CITY OF ALBUQUERQUE

RE: Valle de Atrisco Apartment Development
9901 Ceja Vista Rd. SW
Permanent C.O. – Not Accepted
Engineer's Certification Date: 11/20/20
Engineer's Stamp Date: 09/27/18
Hydrology File: P09D002D

Based on the Certification received 11/20/20 and site visit on 01/22/20, this certification **is not** approved in support of Permanent Release of Occupancy by Hydrology. We can entertain giving a Permanent Release of Occupancy for a portion of the site but the following comments need to be addressed for approval of the above referenced project:

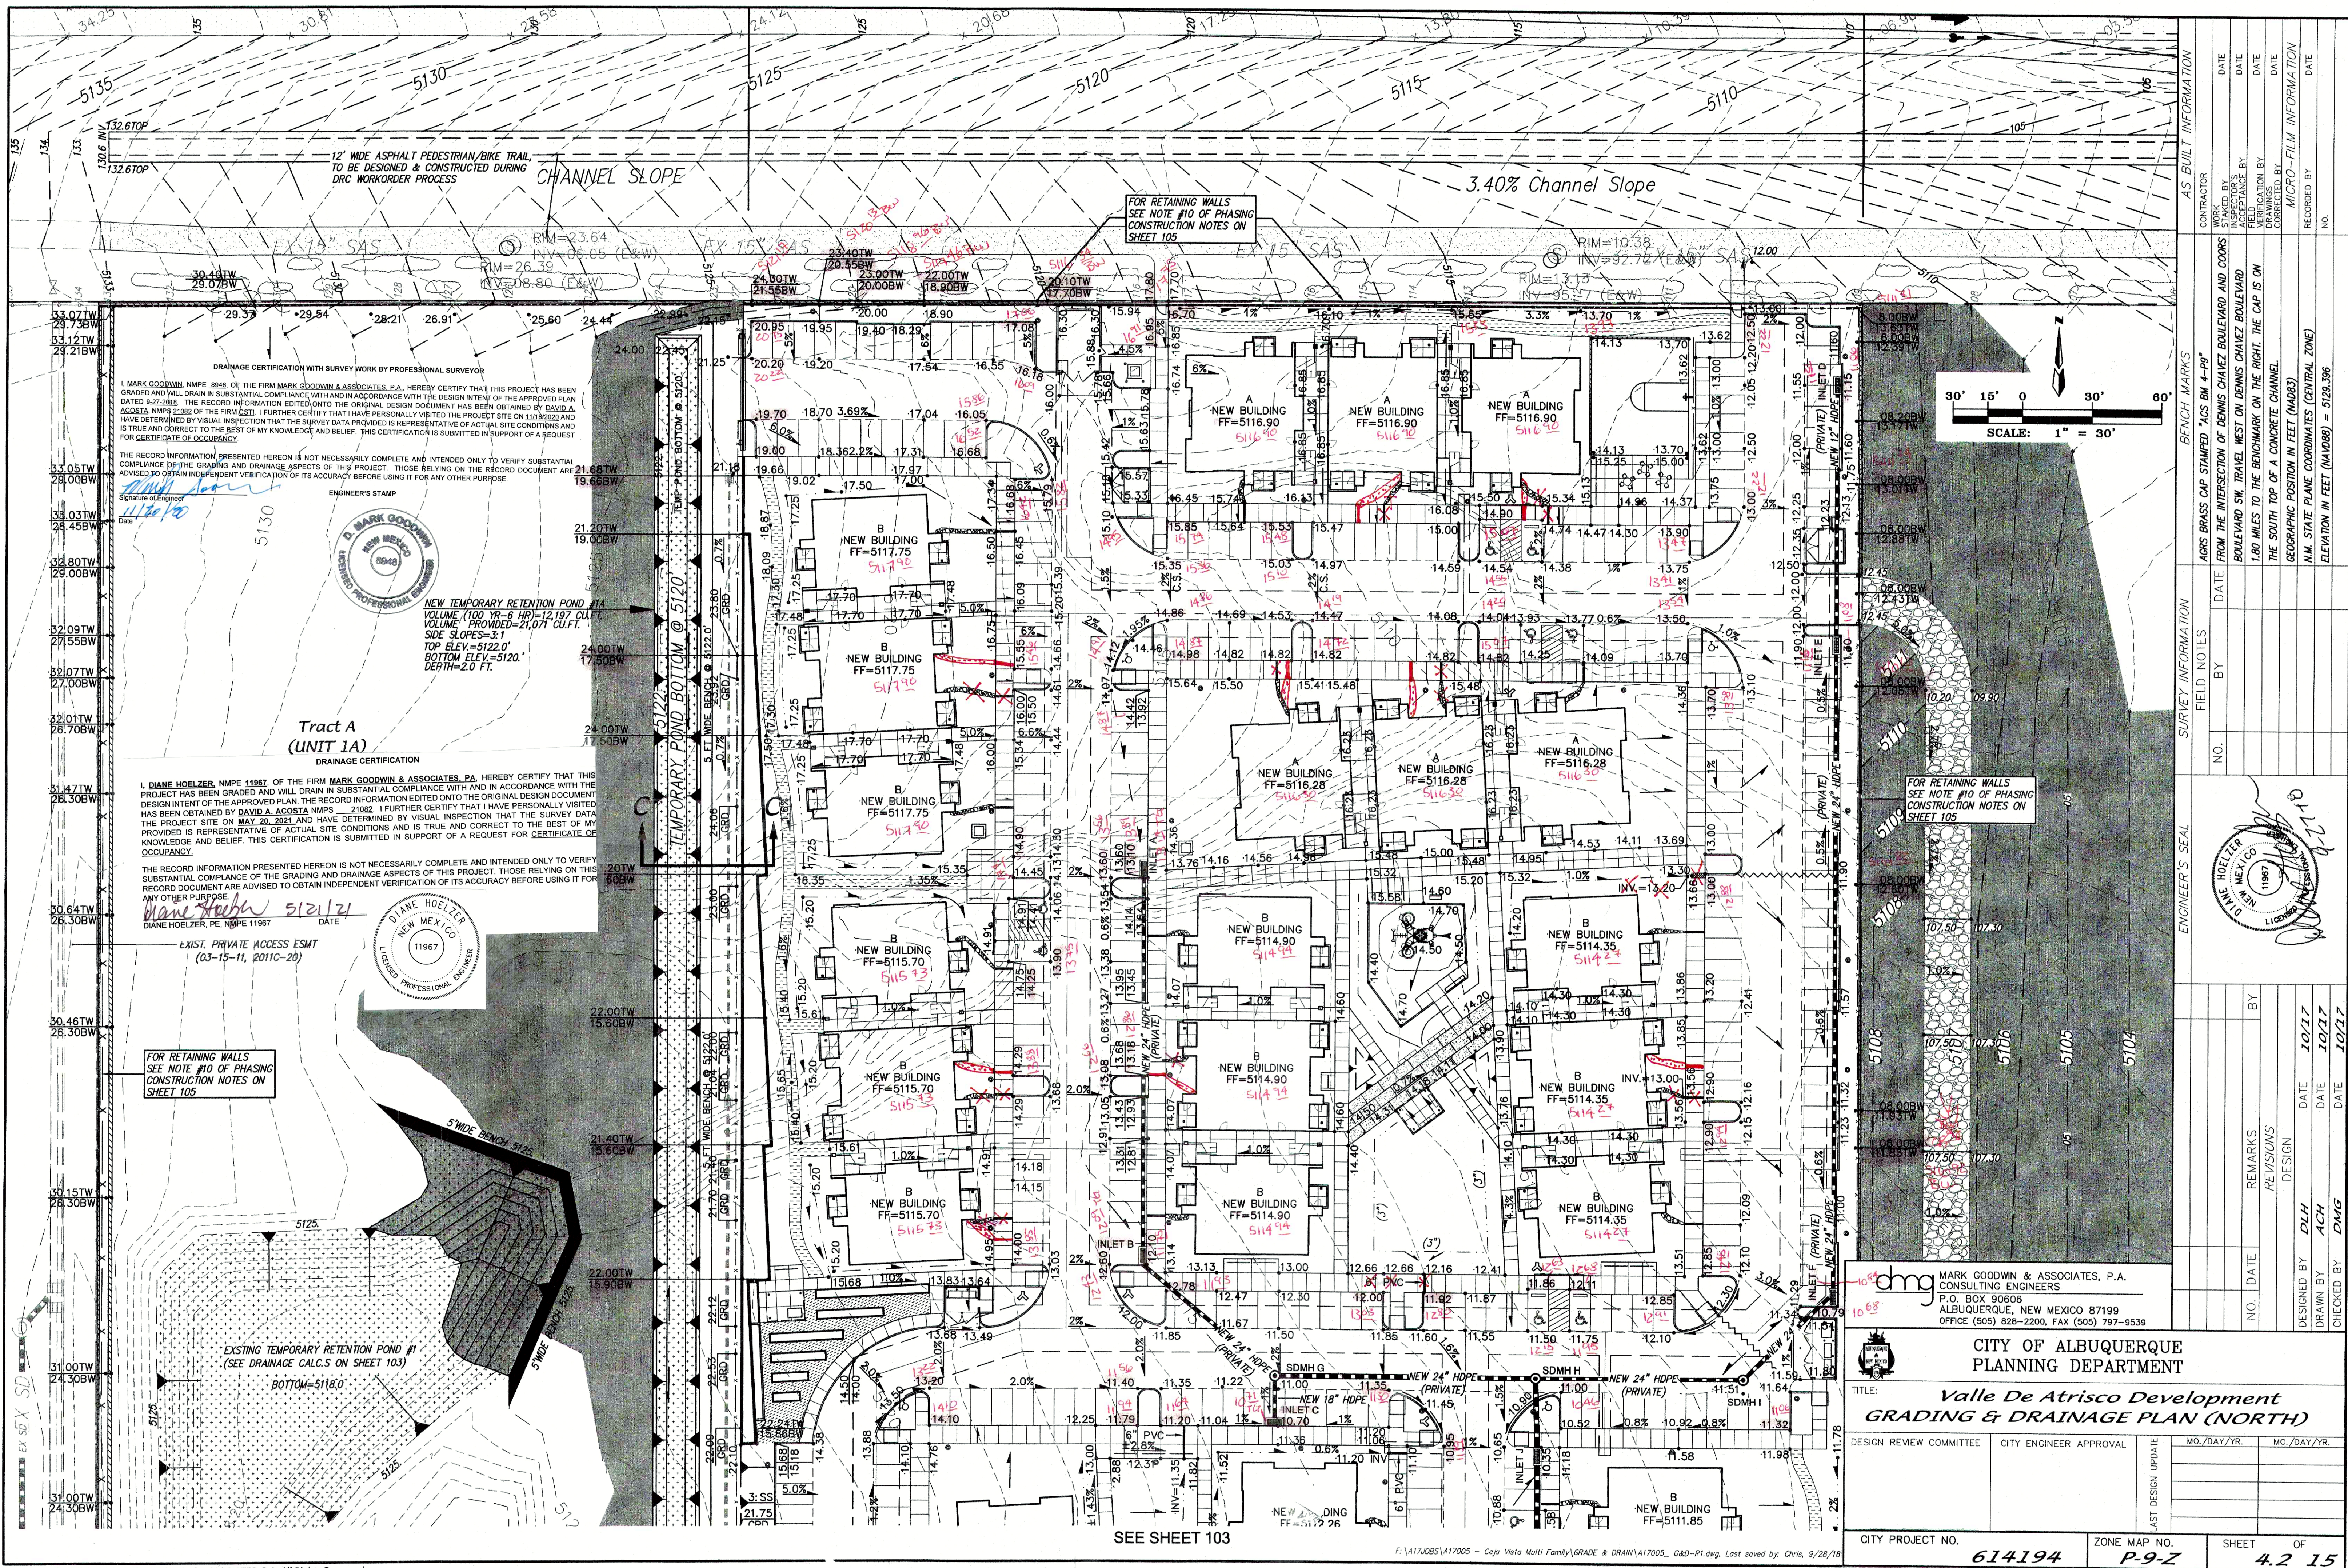
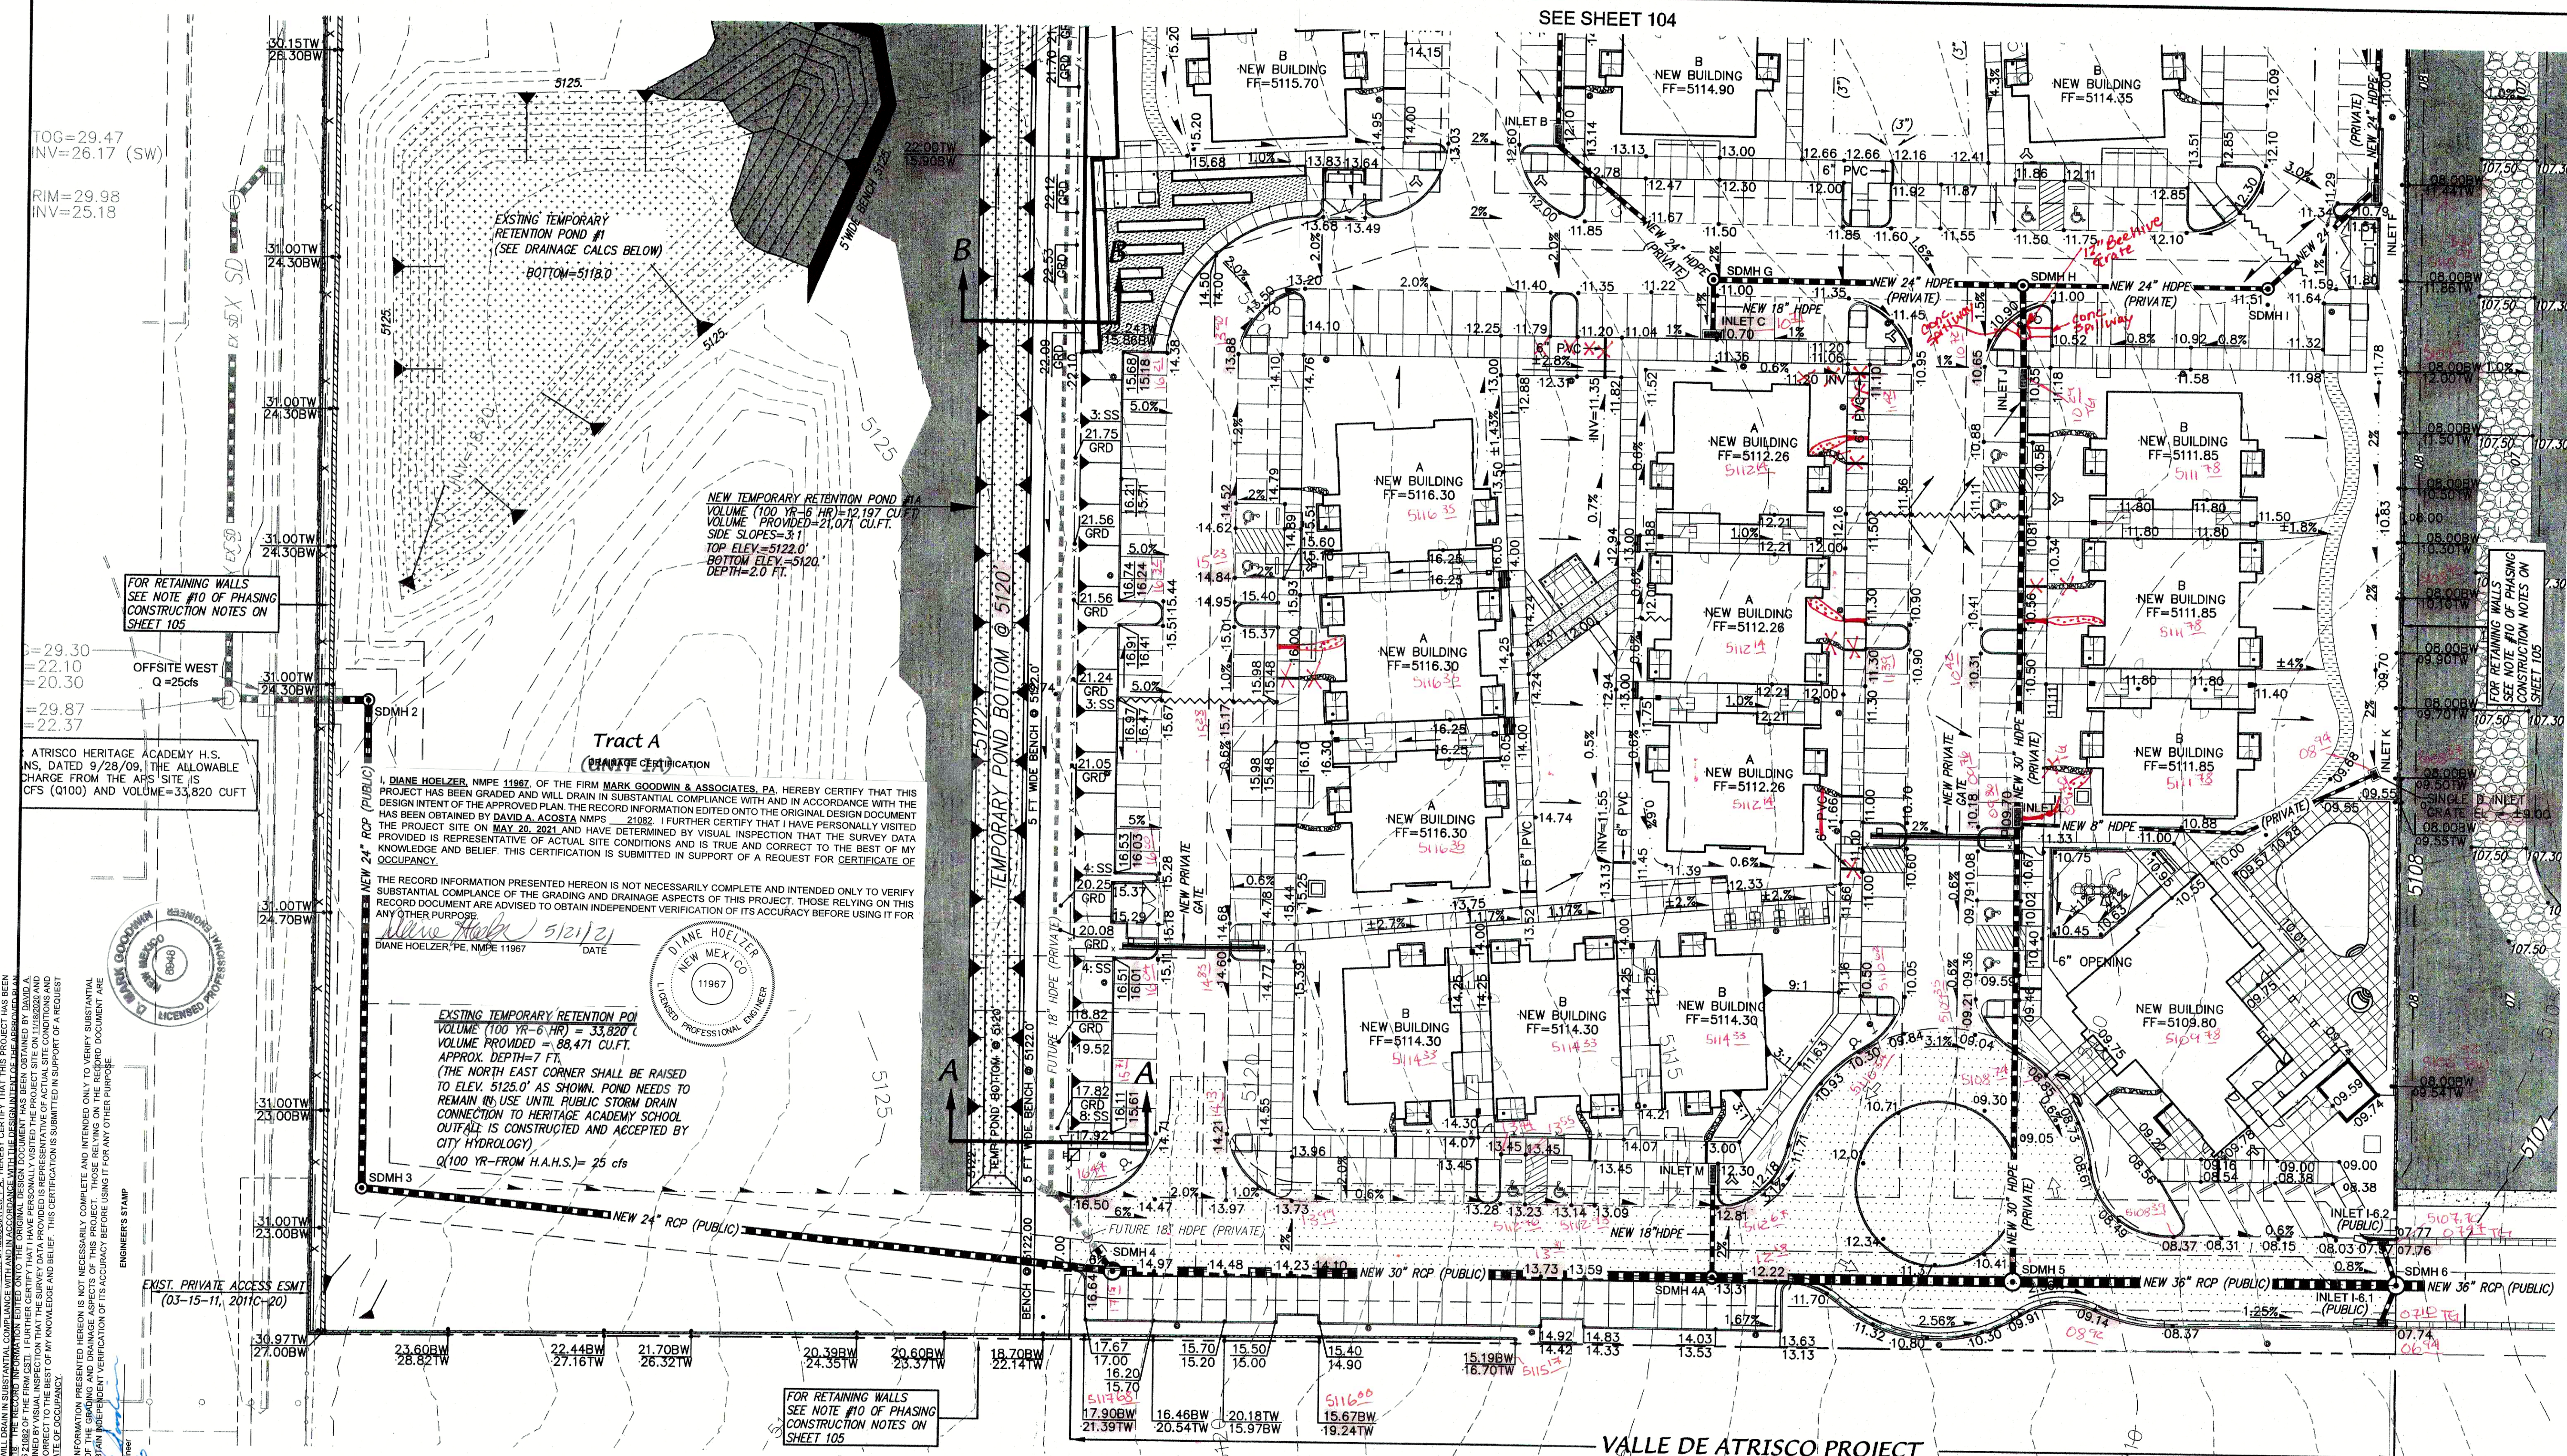
2. The plans that you certified was not the as-built survey of the project. There was an inlet and curb rundowns that were constructed that were not shown on the certified Grading & Drainage Plan. Please get all drainage changes on your resubmittal. See Photo below.

- Also, on the approved Grading & Drainage Plan called out several 6" pvc pipes but sidewalk culverts were constructed instead. Please note that some were double sidewalk culverts and some were single. Again, please get all drainage changes on your resubmittal.

- This last one is actually something that was on the work order but it makes me question all of the as-built survey points. As shown on the certified Grading & Drainage Plan, it stated that grades at the entrance of the Apartments will drain to the Type A inlet at the entrance. However, as I was leaving I notice some water that the contractor had used to wash something. But this drainage did not flow as designed or as you had certified. This did pond and drainage across the drive but it still did not flow the Type A inlet on the other side. It appears that both Type A inlets were installed as a waterblock to the site so this drainage will have to be addressed in the Work Order. See Photos Below.
